FINAL PLAT
STIMPLE SUBDIVISION FILING NO. 1

A PORTION OF SECTIONS 21 AND 22. TOWNSHIP 12 SOUTH, RANGE 65 WEST OF THE SIXTH PRINCIPAL MERIDIAN, EL PASO COUNTY, COLORADO

SHEET 1 OF 2
OCTOBER 3, 2024
JOB NO. 1185.80
STIMPLE SUBDIVISION FILING NO. 1

FINAL PLAT STIMPLE SUBDIVISION FILING NO. 1

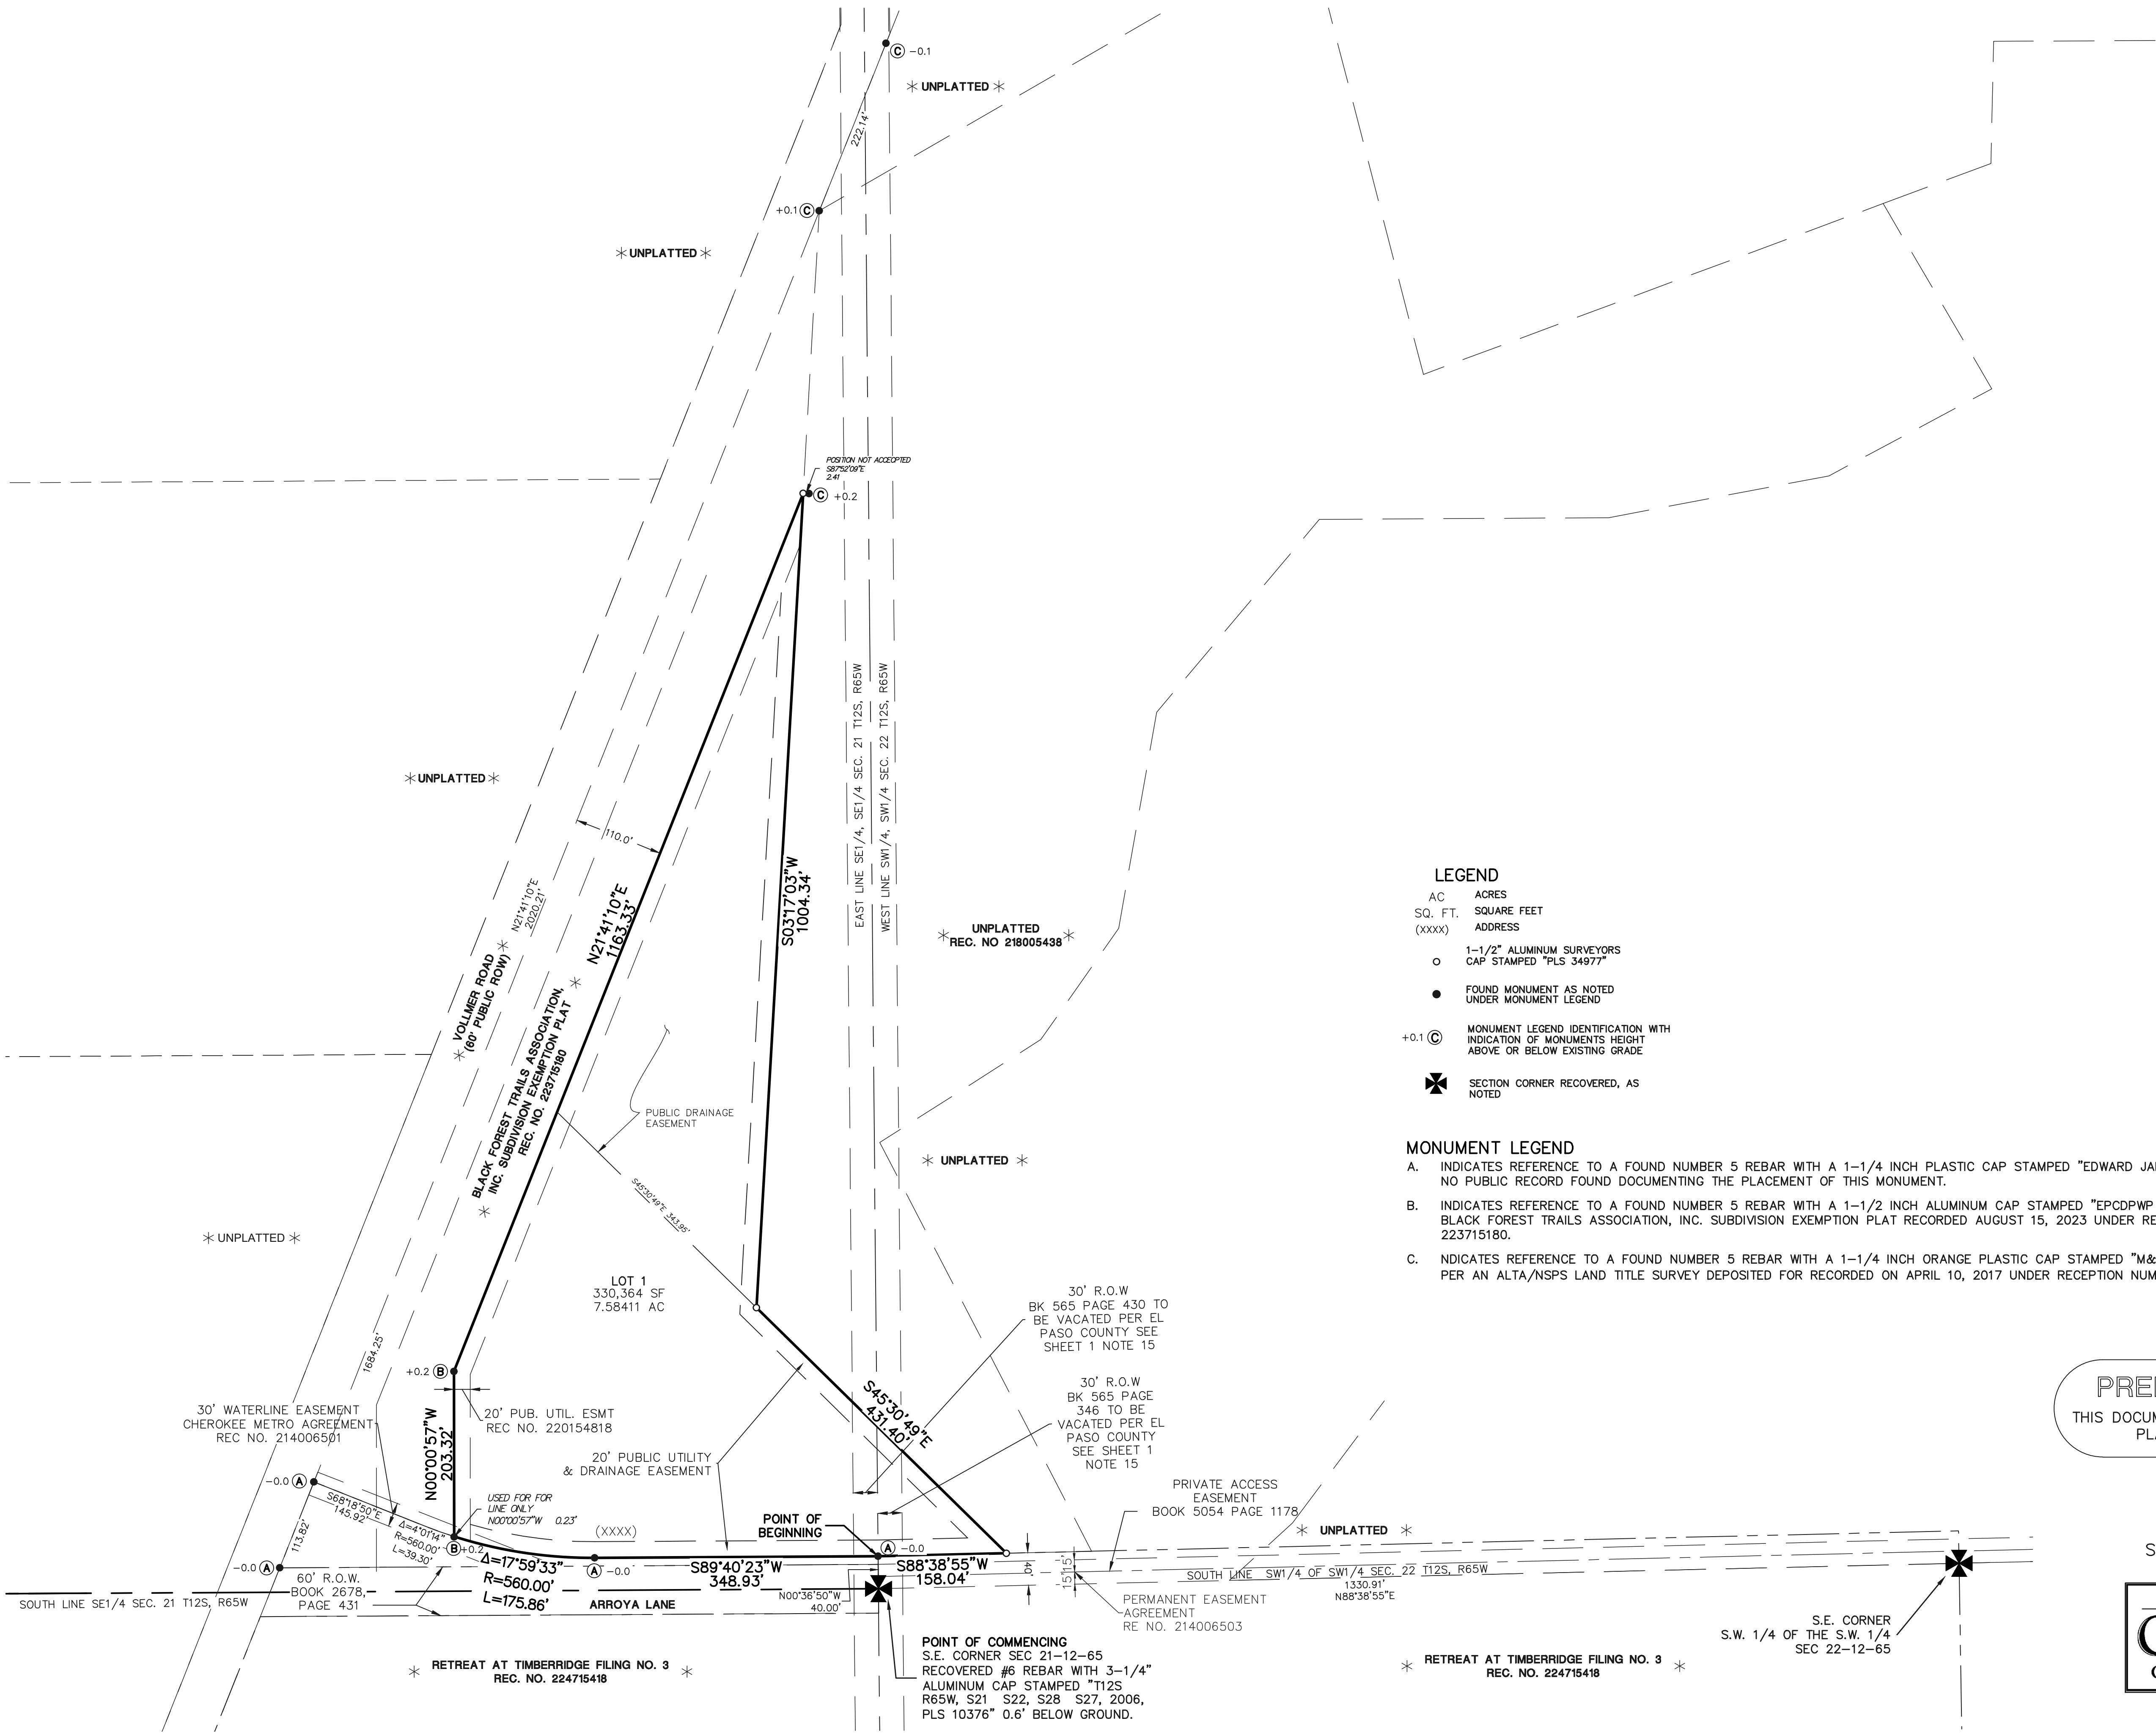
Per comment on previous plat submittal, please ensure that the Closure Sheet matches the bearings and lengths on the submitted plat, or provide reasoning as to why they should be allowed to differ.
